Department of Planning, Housing and Infrastructure (Major Projects)

Your reference: SSD-80471210

State Significant Development – EIS & DA Exhibition – Electricity Generating Works

Molong BESS 19 Back Saleyards Road Molong NSW 2866, 1//DP542283, 99//DP1020247

The Asset Protection Zone (APZ) provided by the Project facility is shown in Figure 12.

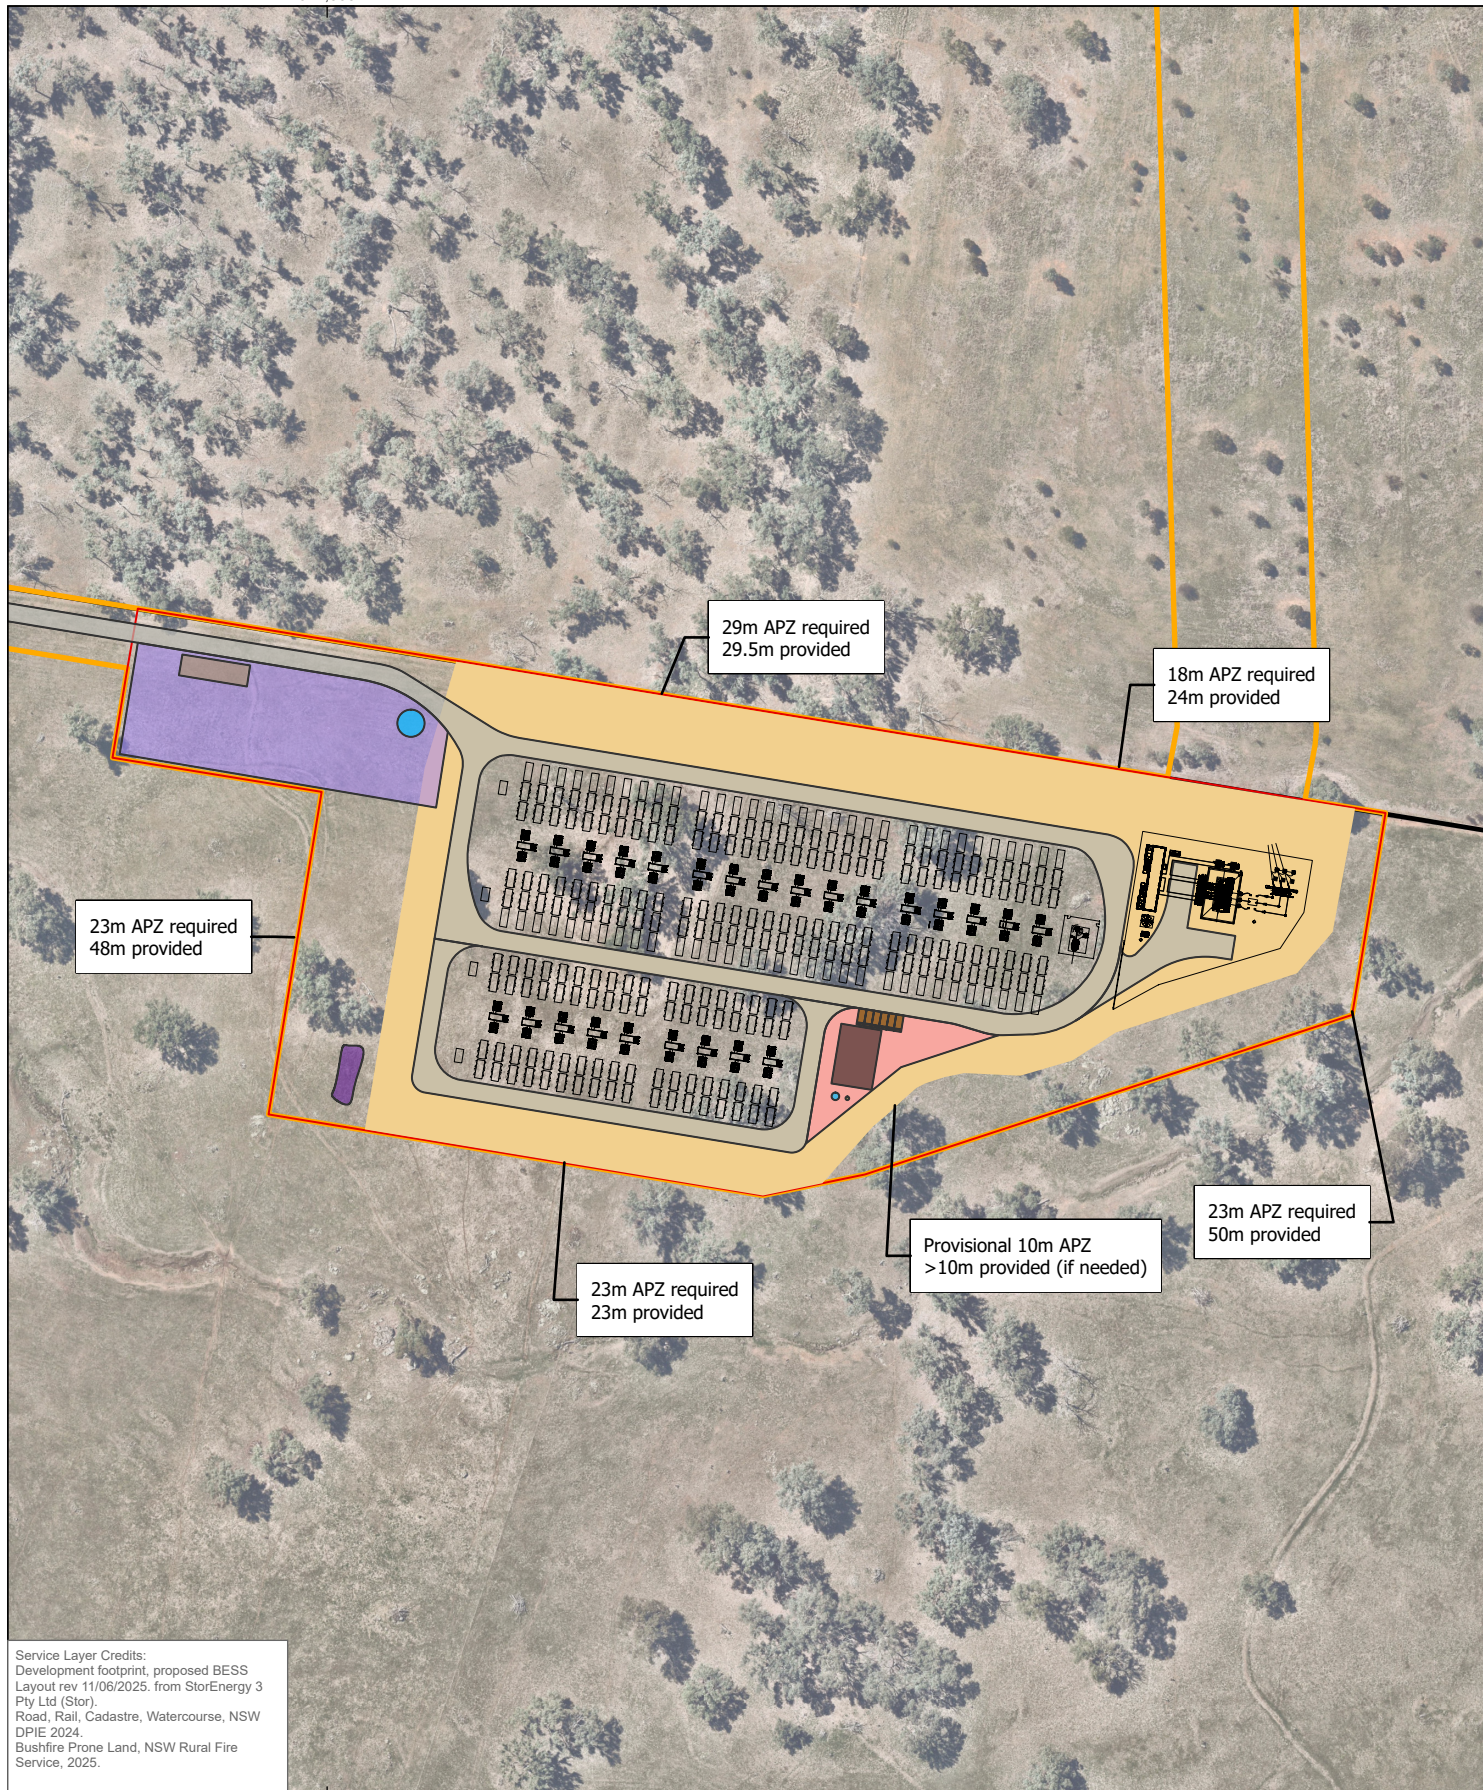
1. From the commencement of building works, and in perpetuity, the property must be managed as an inner protection area to the distances outlined in Figure 12 of the document titled 'Bushfire Risk Assessment Report', prepared by SLR Consulting (Rev: R01-v0.4, dated 28 August 2025) and must be in accordance with the following requirements of Appendix 4 of *Planning for Bush Fire Protection 2019*:

- tree canopy cover should be less than 15% at maturity;
- trees at maturity should not touch or overhang the building;
- lower limbs should be removed up to a height of 2 m above the ground;
- tree canopies should be separated by 2 to 5 m;
- preference should be given to smooth-barked and evergreen trees;
- large discontinuities or gaps in the shrubs layer should be provided to slow down or break the progress of fire towards buildings;
- shrubs should not be located under trees;
- shrubs should not form more than 10% ground cover;
- clumps of shrubs should be separated from exposed windows and doors by a distance of at least twice the height of the vegetation;
- grass should be kept mown (as a guide, grass should be kept to no more than 100mm in height); and
- leaves and vegetation debris should be removed regularly.
